# URBAN DESIGN REPORT

**SUBJECT SITE: 116-118 CARRUTHERS AVENUE**

**REPORT DATE: NOVEMBER 15, 2024**

The following detail the comments regarding Urban Design provided at the pre-application consultation meeting that took place on June 26, 2024.

3D VIEWS

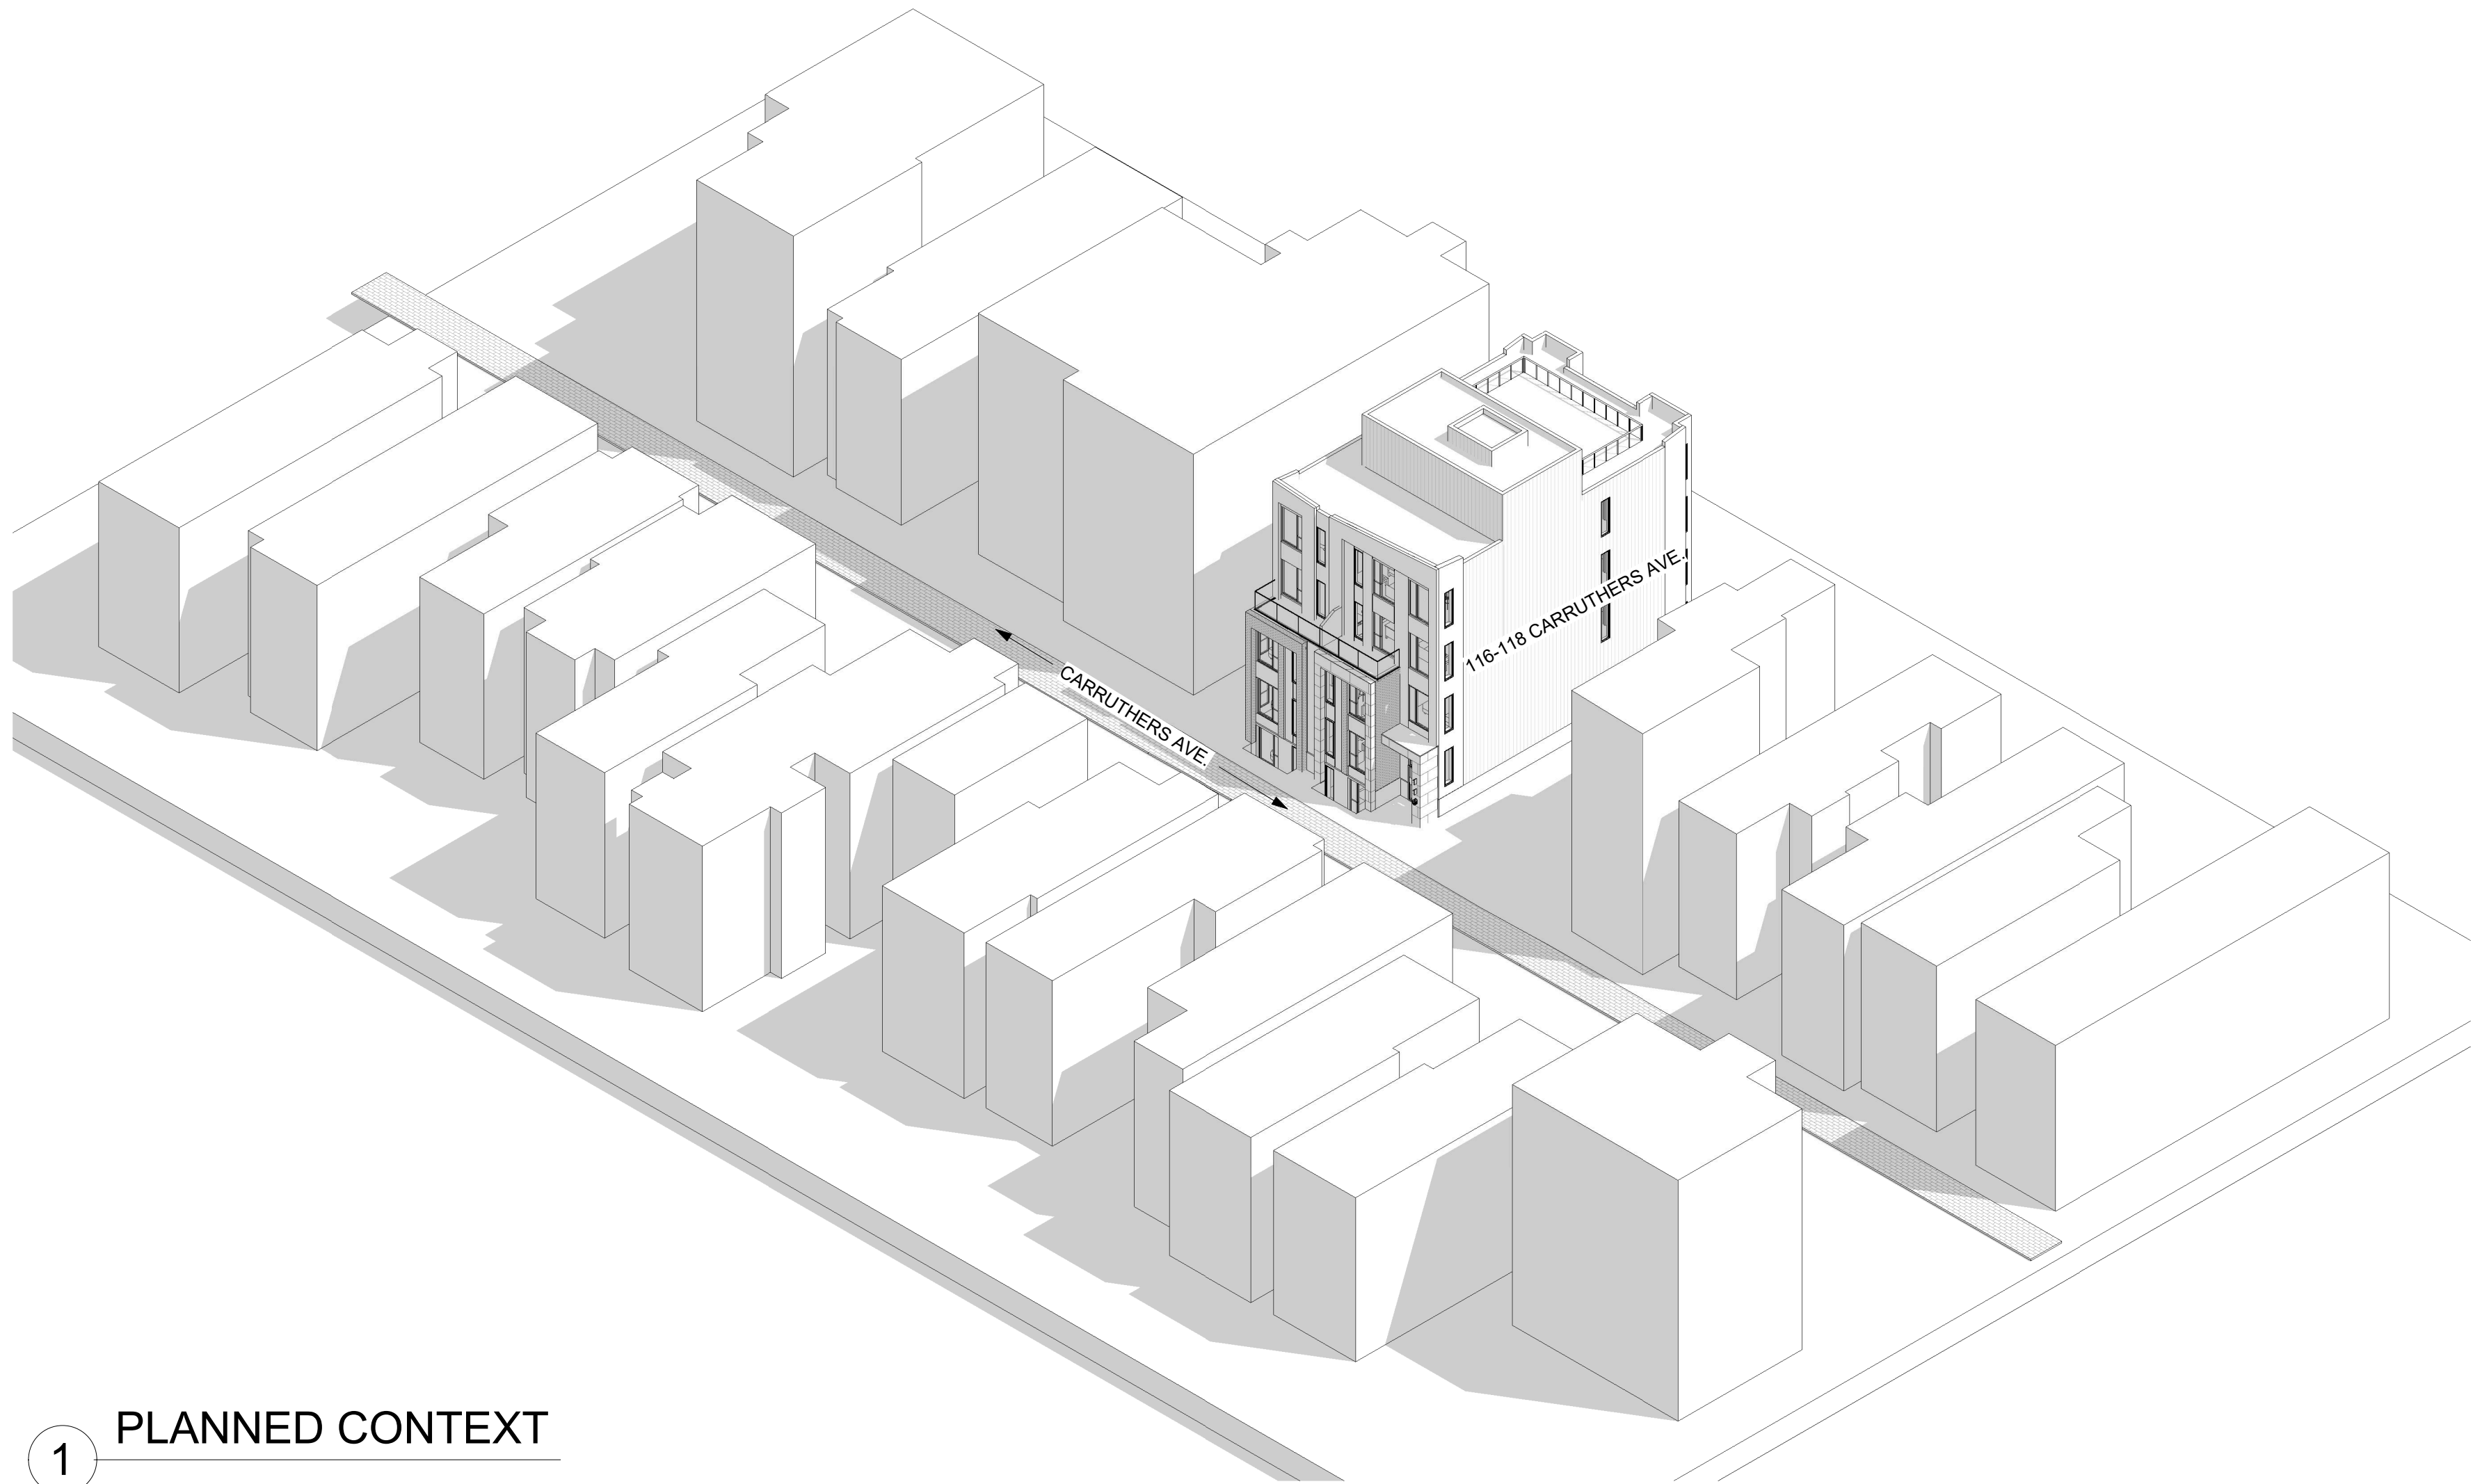
Please show adjacent buildings and demonstrate compatibility with the neighbouring context.	Please see the existing and planned context 3D models in Section 4.0 Design Research of this report.

We recommend providing the built form planned context in the 3D modelling illustrations to help analyze the scale of the proposal in its context. This can be ghosted blocks on the neighbouring properties.

Please see the existing and planned context 3D models in Section 4.0 Design Research of this report.
